City of Albuquerque

RE: ENGINEER'S CERTIFICATION FOR THE JPD WAREHOUSE, (H-16/D126),
ENGINEER'S STAMP DATED 10/27/99,

Re: JPD Warehouse Grading and Drainage Plan (H16/D126)

SUBJECT: **MODIFICATIONS TO DRAINAGE FACILITIES WITHIN PUBLIC
RIGHT-OF-WAY DRAINAGE FILE NUMBER (H16/D126).**

REPLACE TYPE "C" WITH
TYPE "D" INLET

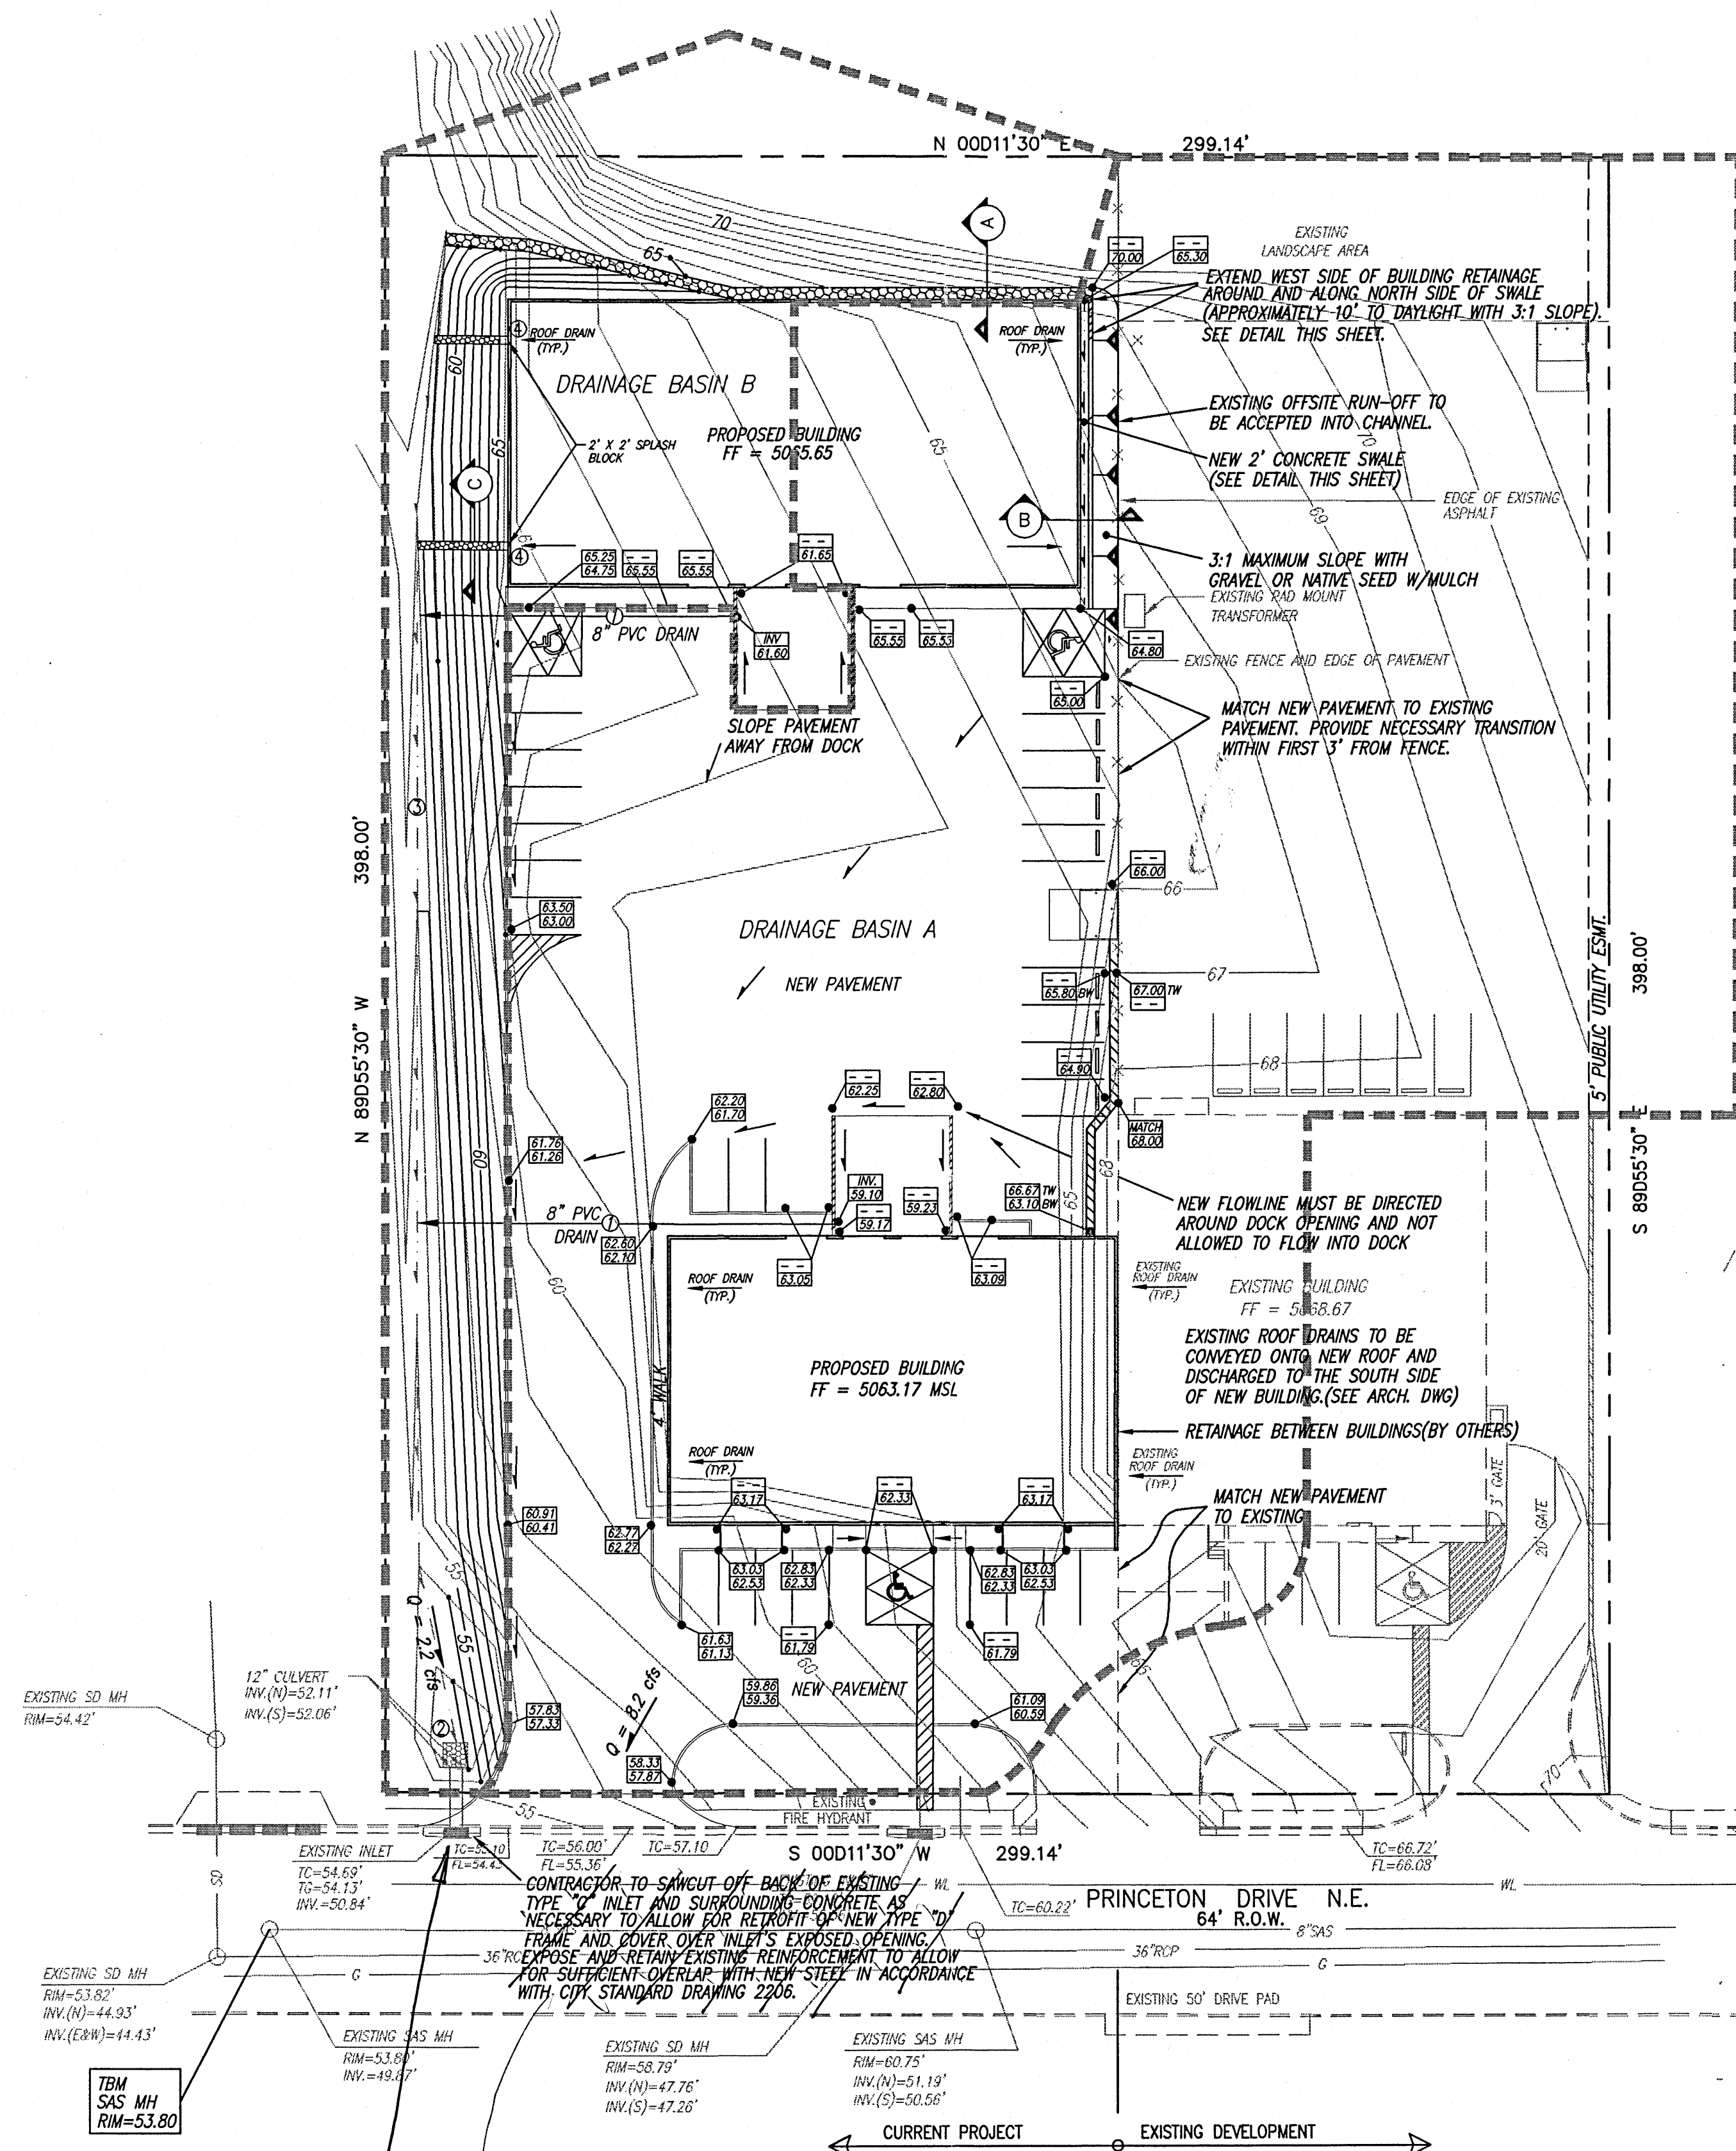
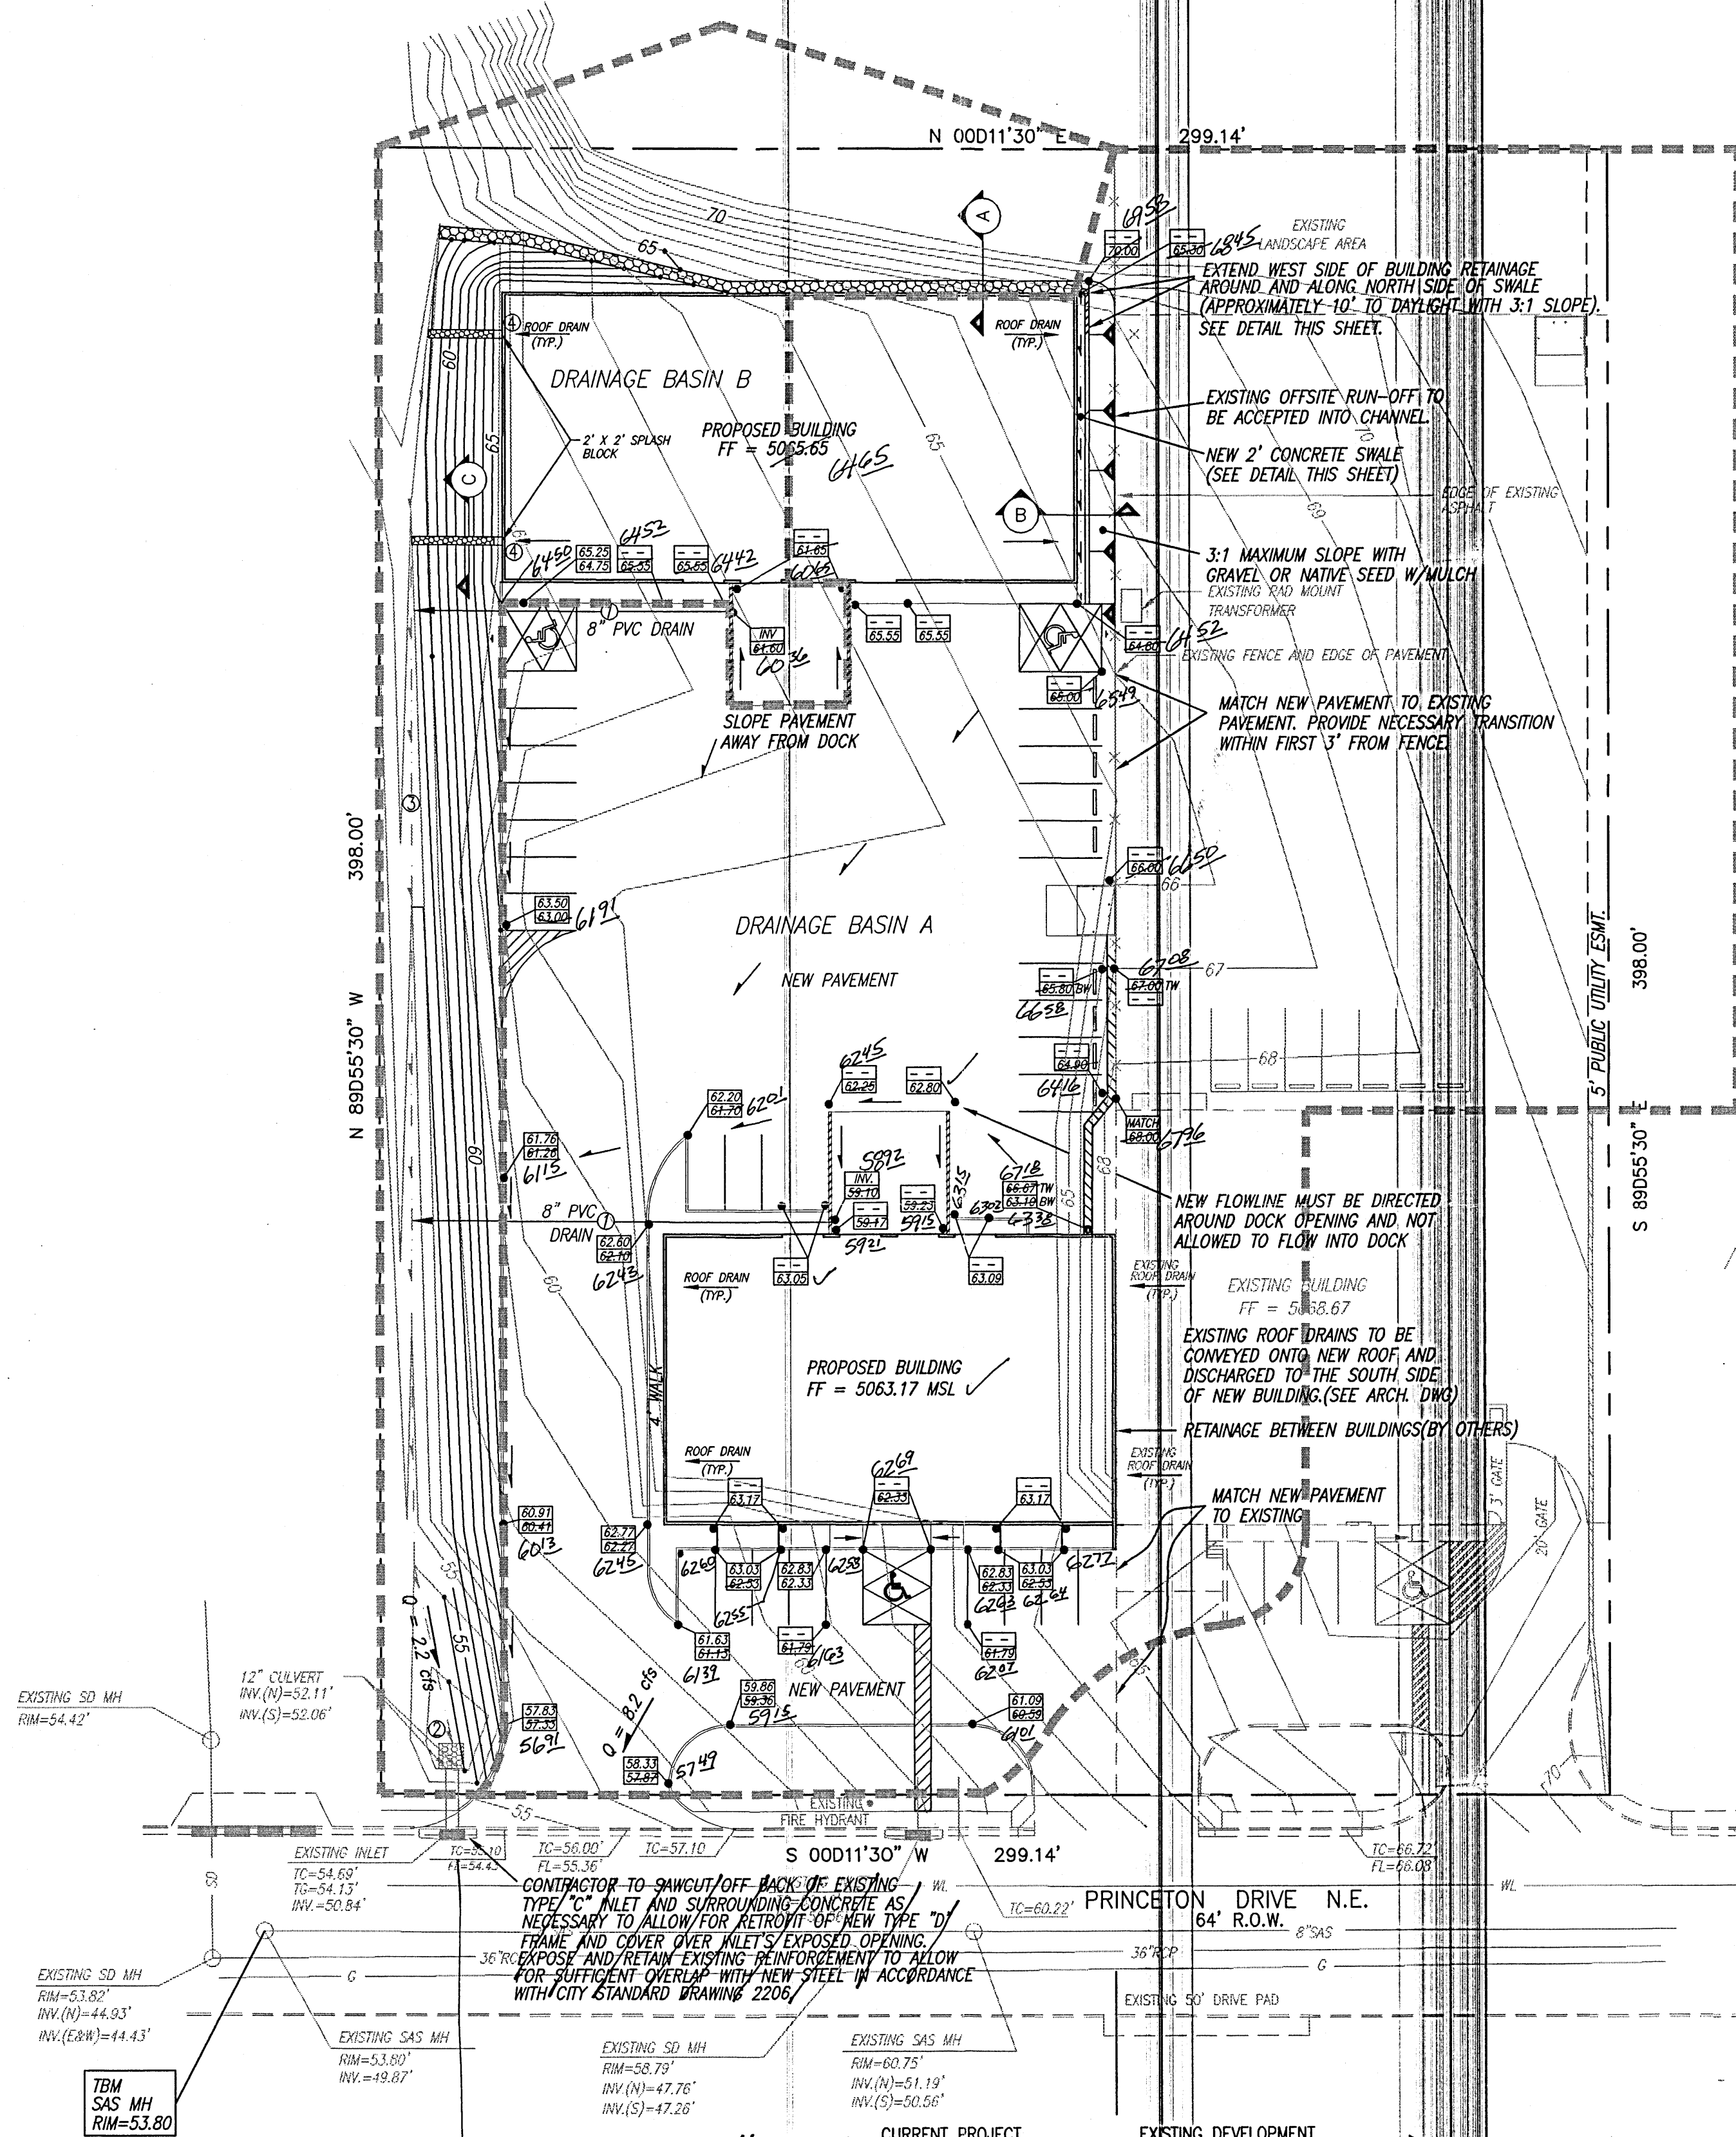
After review of your submittal dated 8-27-99, the above referenced plan is approved for Building, Foundation and SO#19 permits, with the following modification: In lieu of retrofitting existing inlet, replace type 'C' inlet with type 'D' inlet, shown on Princeton Drive, at your new driveway.
